Subject: Discharge of Drainage Conditions - LU/337/19/DOC - CM Wood Body Repair Centre

I have received the following consultation response from our Drainage Engineer:

DRAWING TITLE
SOAKAWAY DESIGN ALTERNATIVE TO PERMEABLE PAVED INFILTRATION SYSTEM

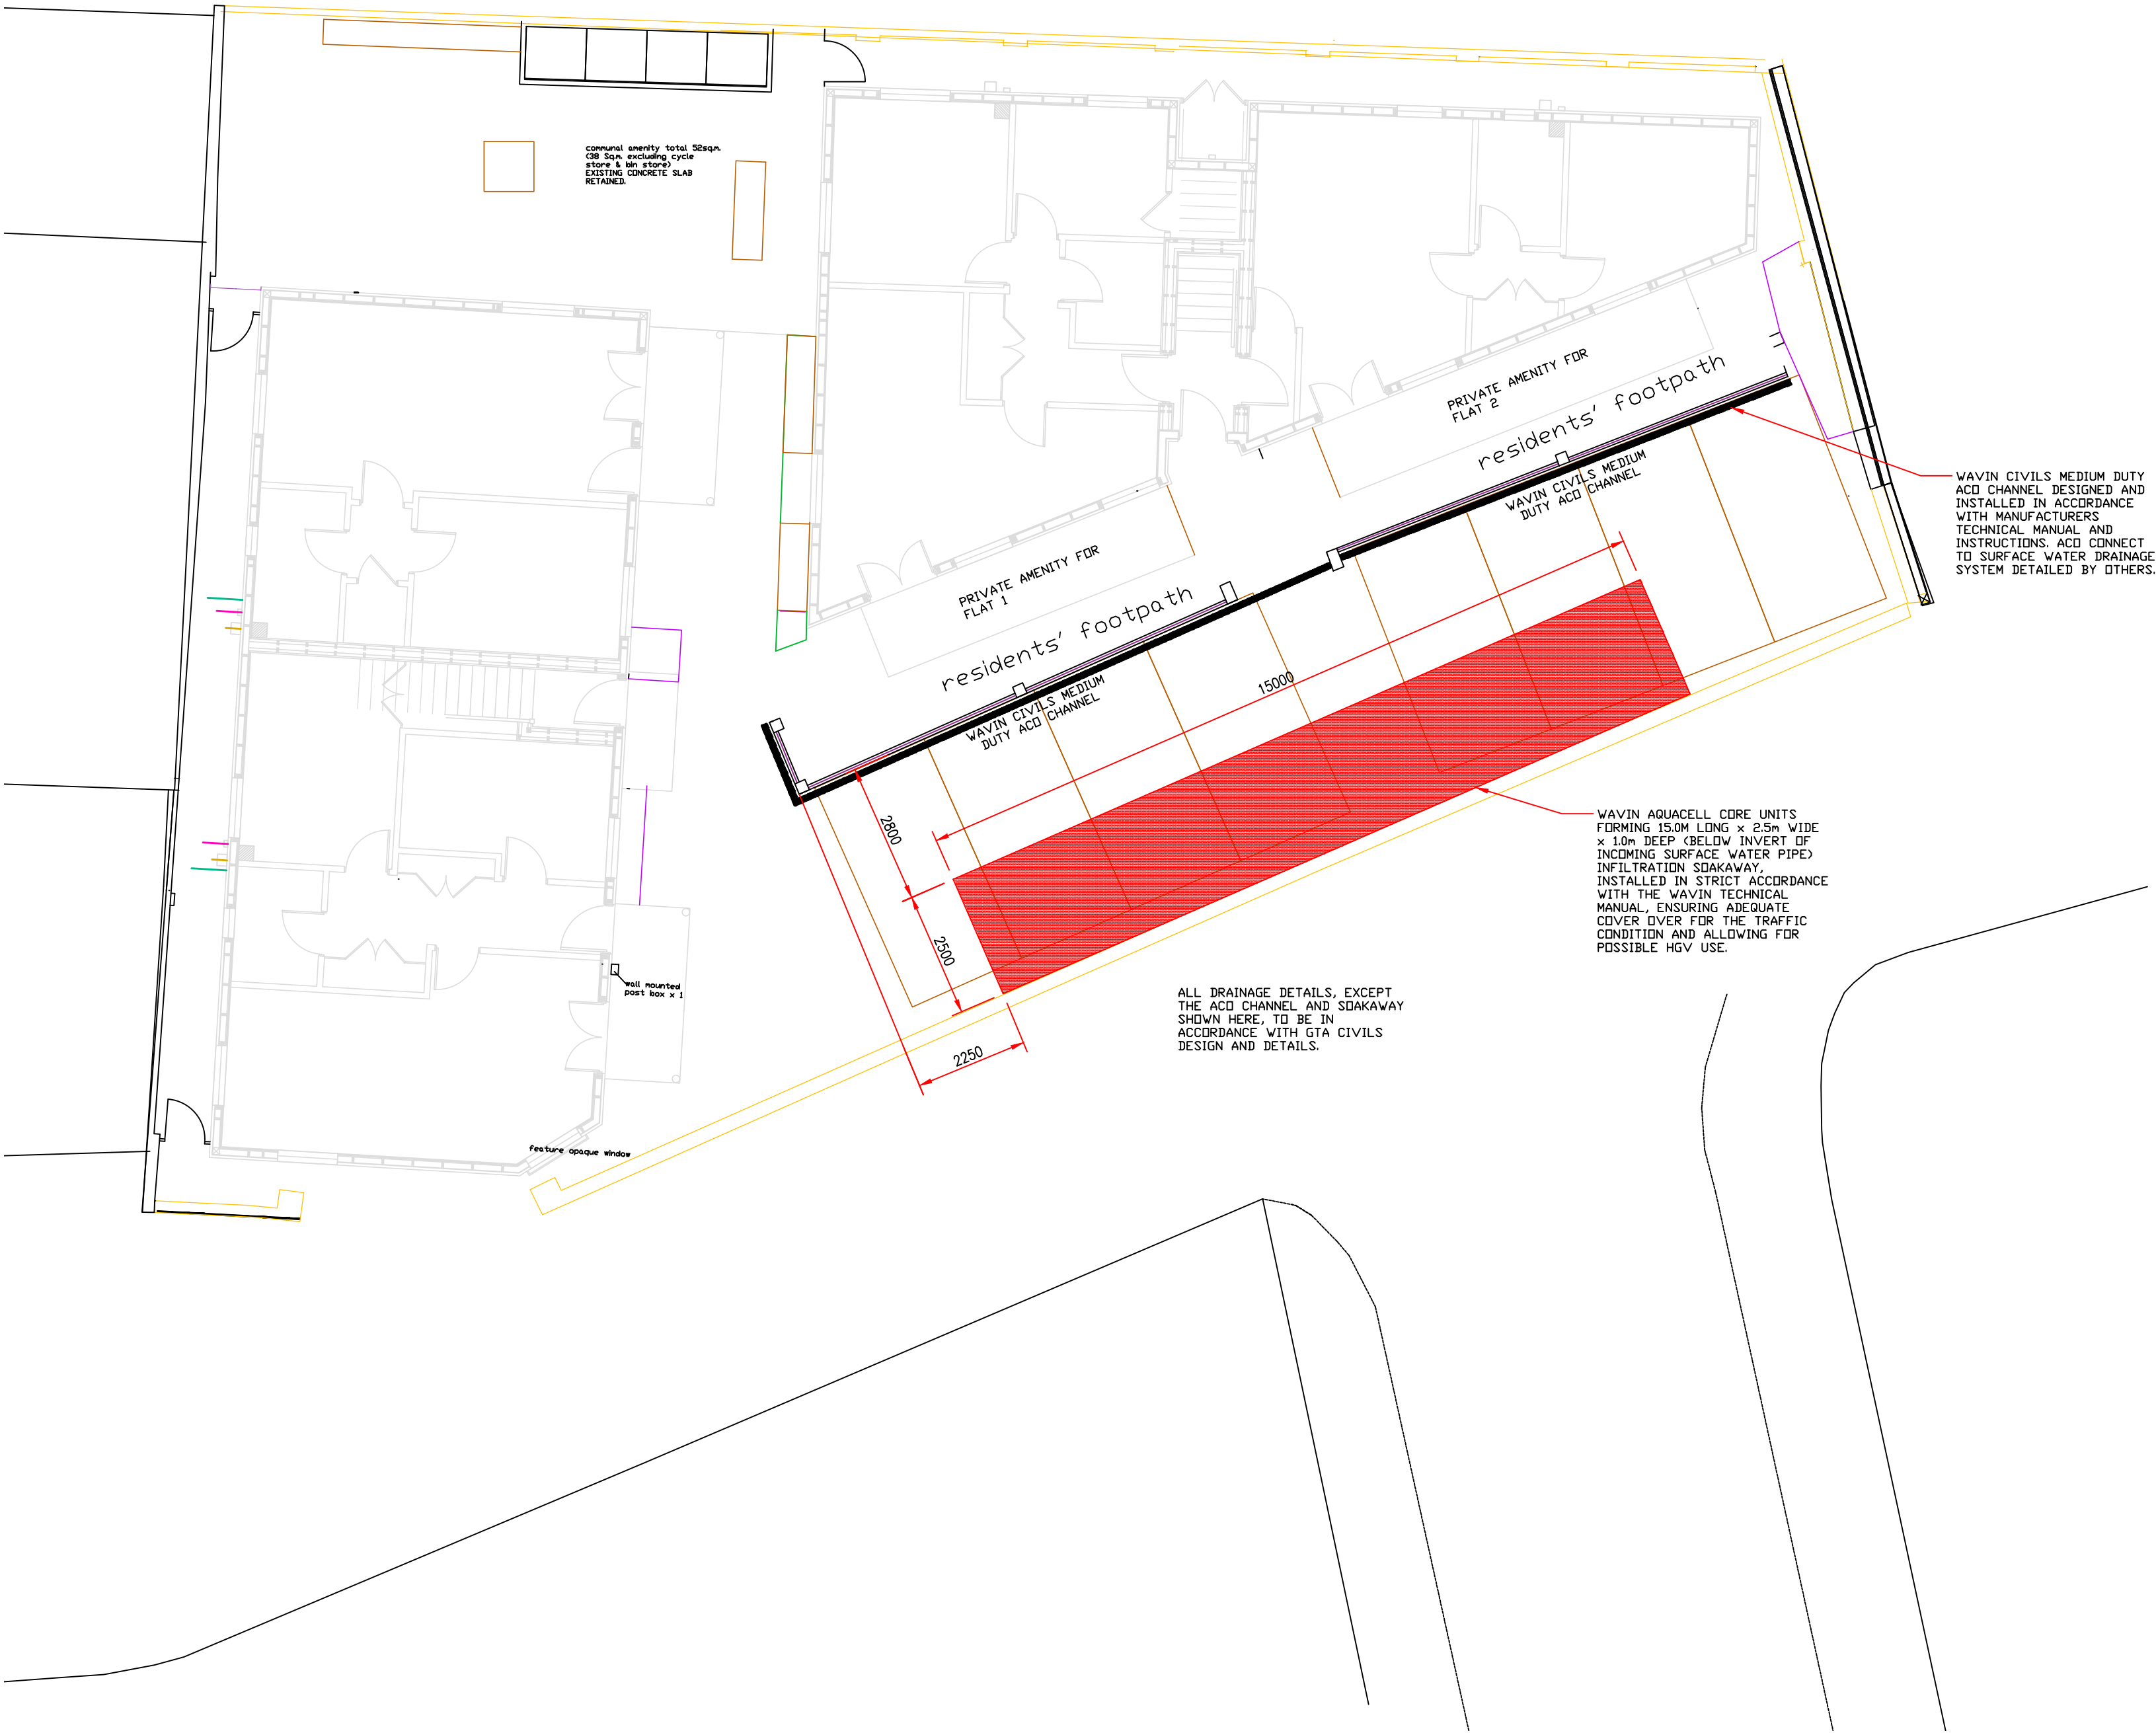
1. Please provide details of infiltration testing and groundwater monitoring. Including the depth that the infiltration tests were completed to. The proposed soakaway is deeper than the agreed permeable paving.
2. Please submit drawing details for the soakaway and ACO channel, including the appropriate cover depths and levels.
3. Please include the location of pipes and manholes on the Drainage Layout, please label these with their diameters, materials, cover levels, invert levels and falls as appropriate.
4. The calculations have confused the dimensions of the soakaway. The depth is 1m (1000mm) rather than 14776mm. Please adjust accordingly.
5. Please add 40% allowance for climate change.
6. Please provide silt traps upstream of the connection to the soakaway and show these on the drainage layout.
